Recommendation Report for Consent to Display an Advertisement(s)

REF NO: BR/167/25/A

LOCATION: Pavement o/s Iceland
72-74 High Street
Bognor Regis
PO21 1SJ

PROPOSAL: Removal of existing BT Phone Kiosk and installation of 1 No new BT Street Hub, incorporating 2 No digital 1.905m internally illuminated LCD advert screens.

Drawing Title
EXISTING AND PROPOSED
ELEVATIONS

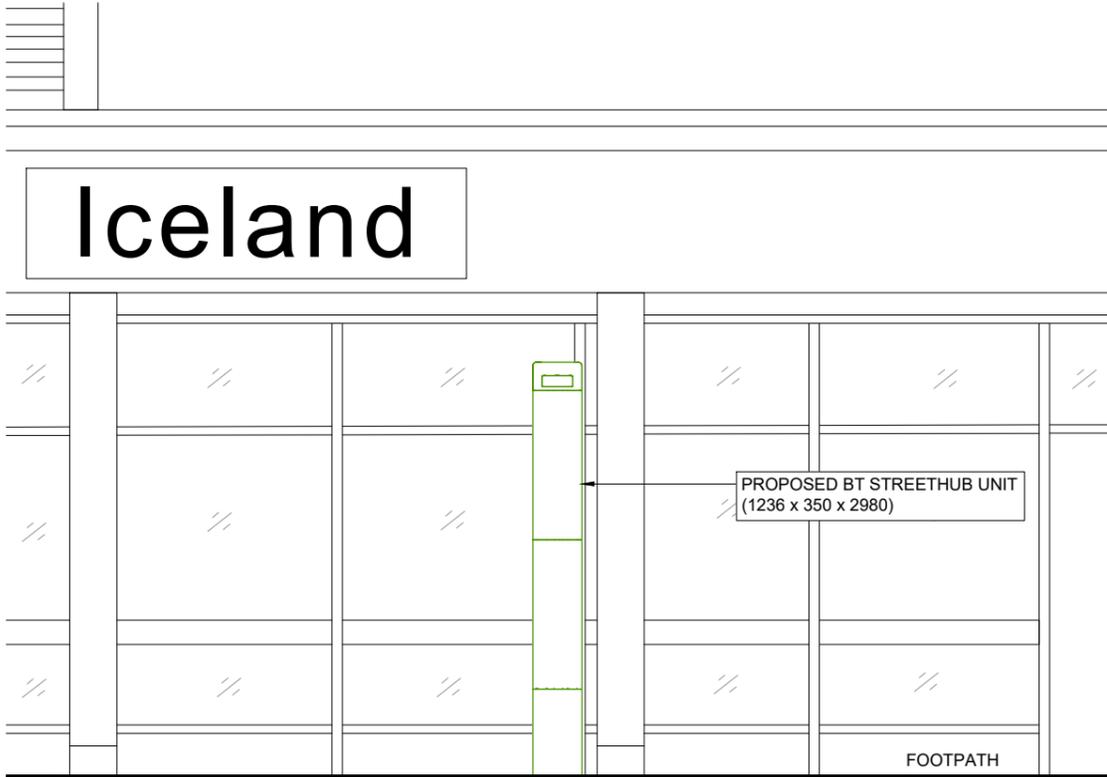
The Streethub will have two digital internally illuminated screens with a size of 95cm in width and 167cm in height to both elevations.

The illuminance levels are proposed at 600cd/m² between dawn and dusk. WSCC Highways have provided comment given it is located on land maintained as public highway. They state that given the High Street would be considered an E3 area (Medium District Brightness), that this be reduced to 300cd/m² during the hours of darkness, as per the guidance outlined in the Institute of Lighting Engineers' Professional Lighting Guide 05/23 "The Brightness of Illuminated Advertisements including Digital Displays" (2023). This has been agreed with the applicant and illuminance levels will be conditioned.

5 The intensity of illumination of the proposed sign shall not exceed 300 cd/m² between the hours of dusk and dawn.

Drawing Title
PROPOSED SITE PLAN

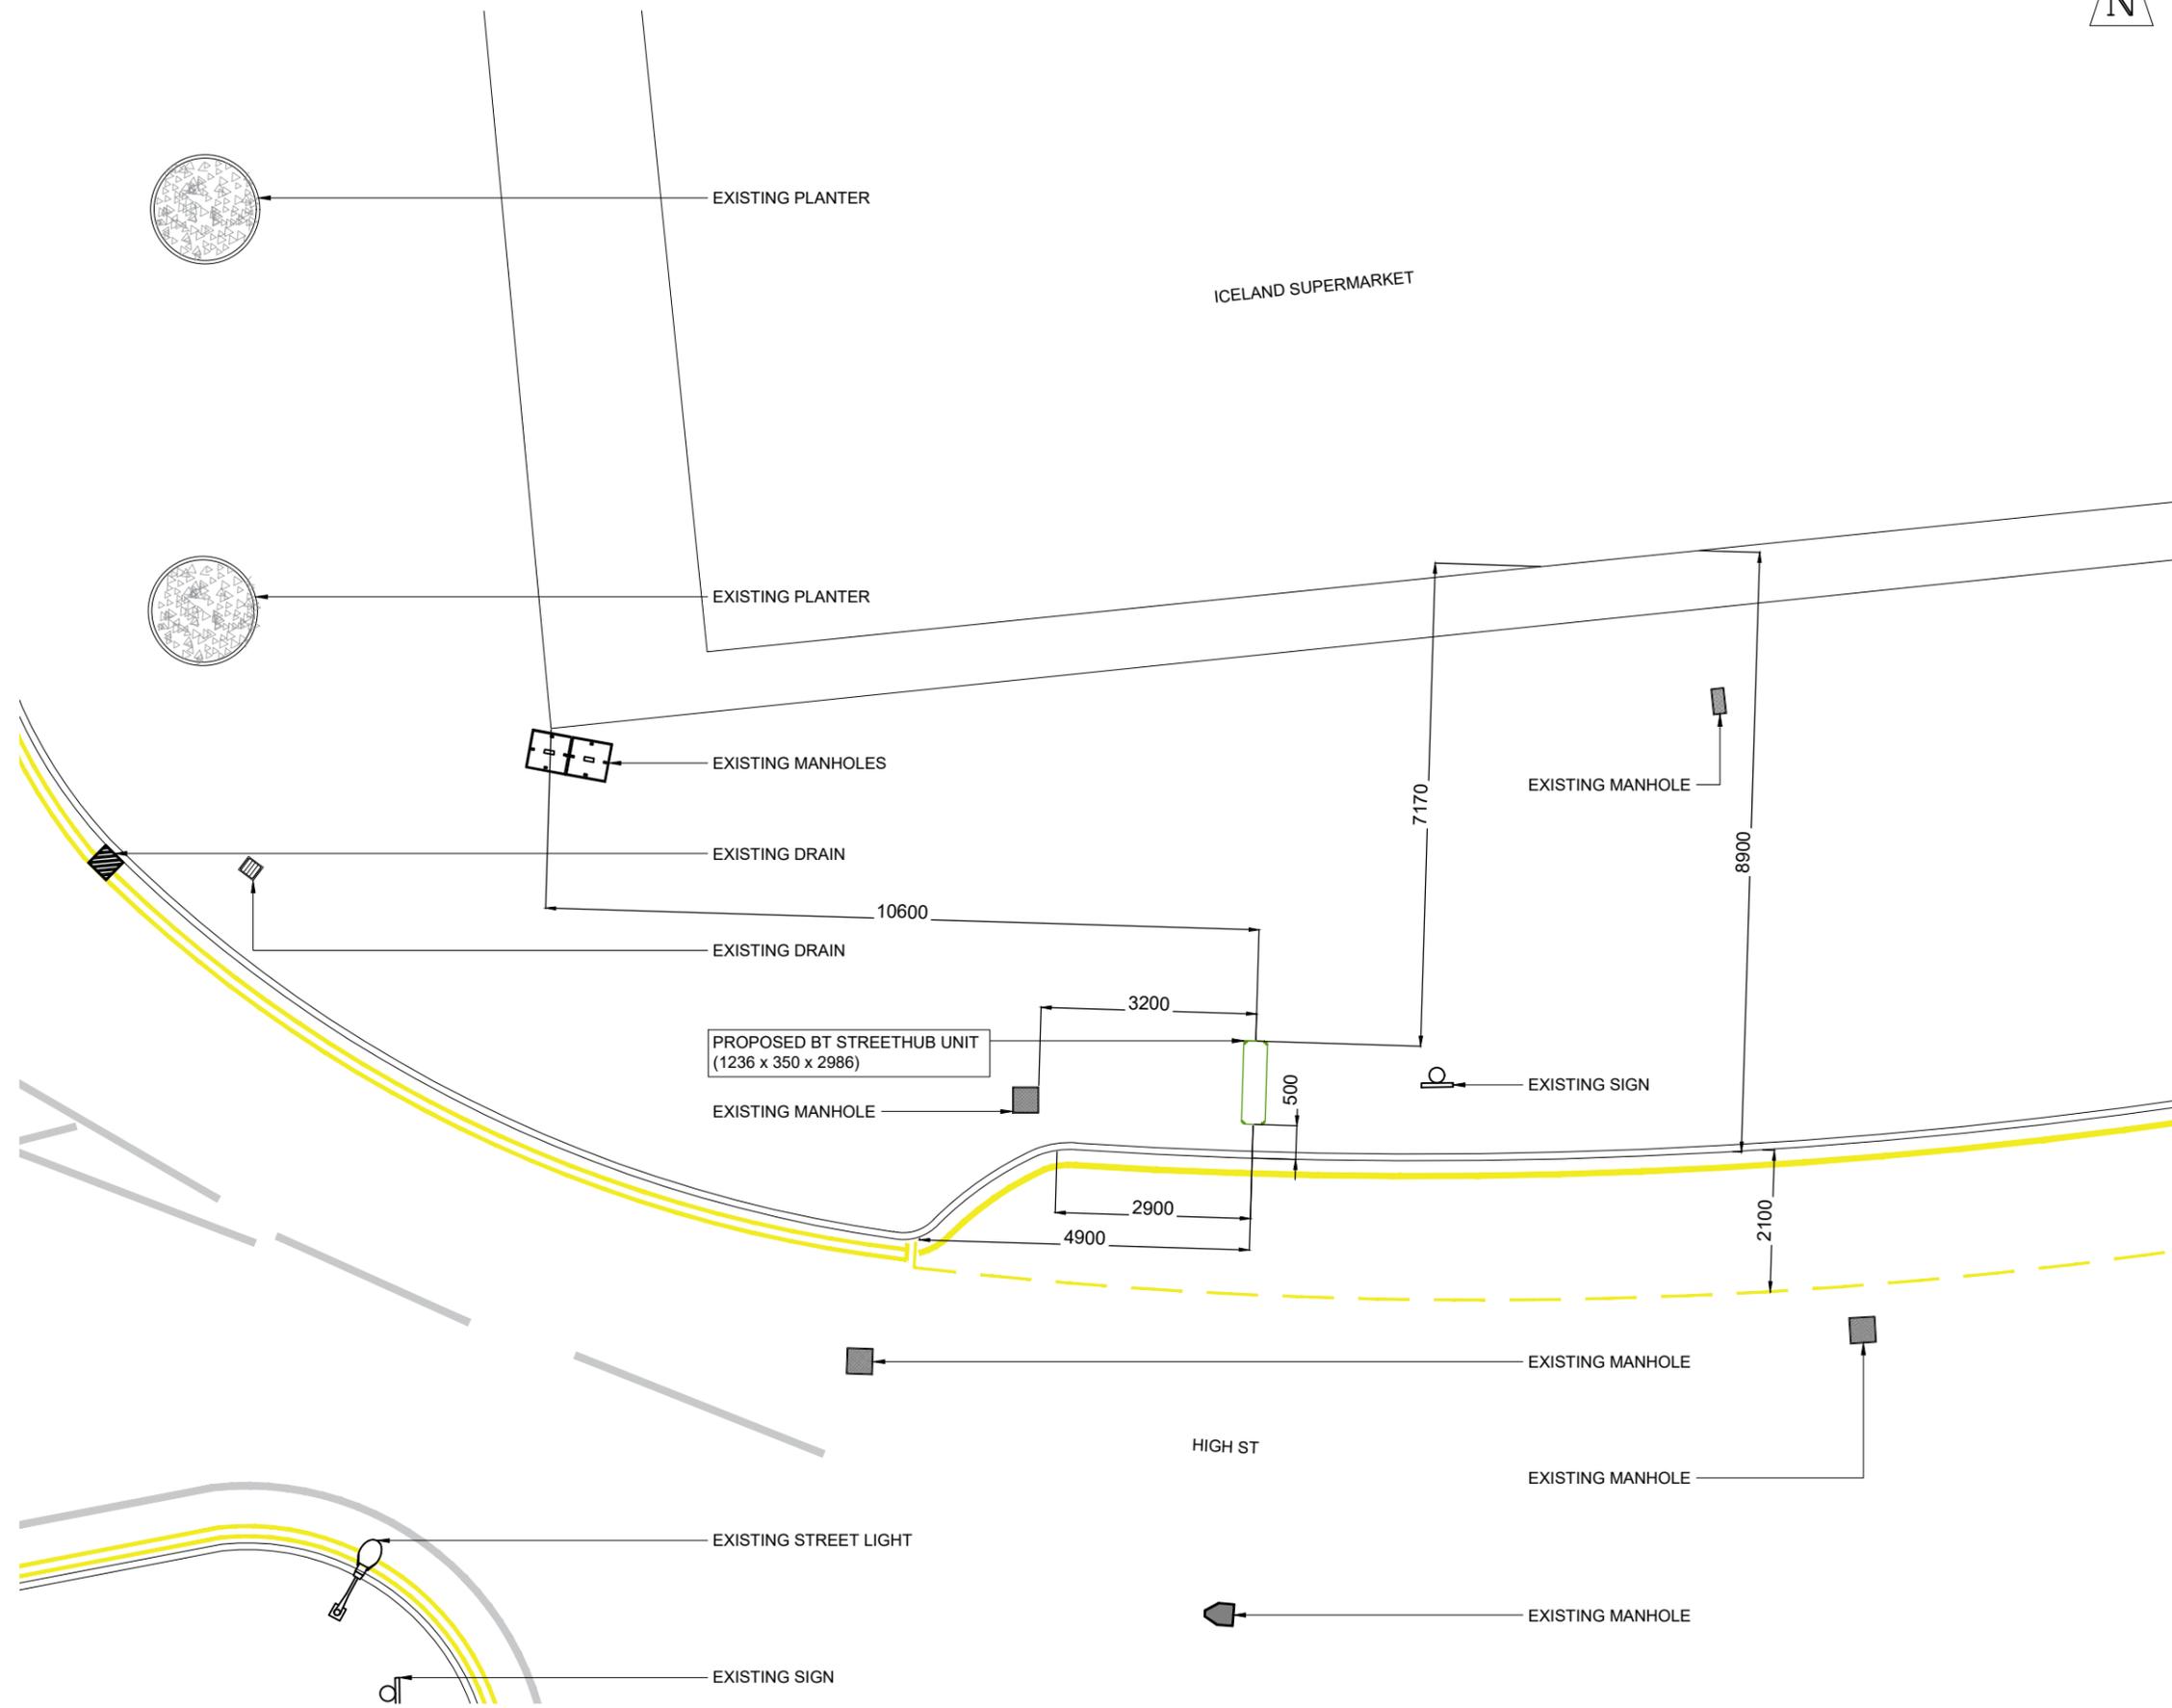
- The proposed location is not anticipated to result in an obstruction to pedestrians utilising the footway, nor to result in an obstruction to vehicular visibility for vehicles travelling on High Street.
